**Re:** Foundation Observation  
Lot 1147 ACC  
245 Education Drive  
Springs Lake, NC 28390  
D.O.I.: April 29, 2021

On April 29, 2021, Chicora, PLLC performed a site review requested by the client Floyd Properties to observe a void in the proposed foundation footing. Please see the attached drawing for an approximate location of the area observed.

Approximate Location

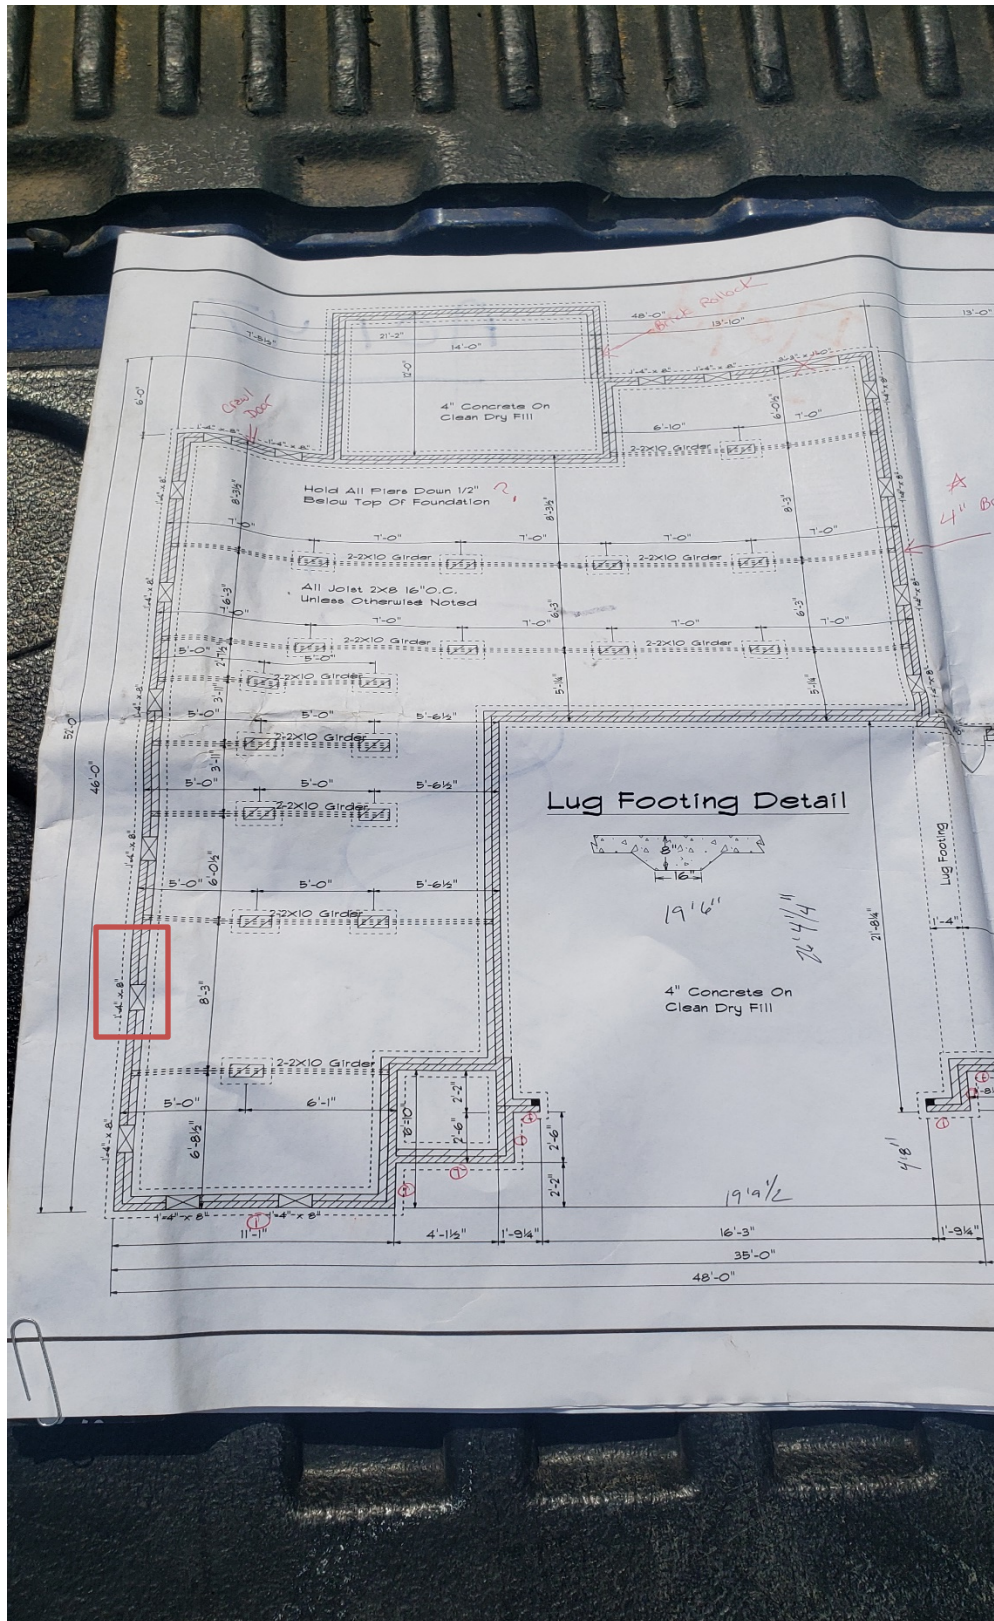
Chicora, PLLC meet with the foundation subcontractor on site and observed the area. The area was identified as a location where a tree stump was removed during the footing excavation. Chicora, PLLC probed the area with a probe rod to verify the soil stability.

Chicora, PLLC recommends to excavate the area by 2ft (length) x 2ft (width) x 2ft (depth) and place concrete in the area during the placement of concrete for the footings.
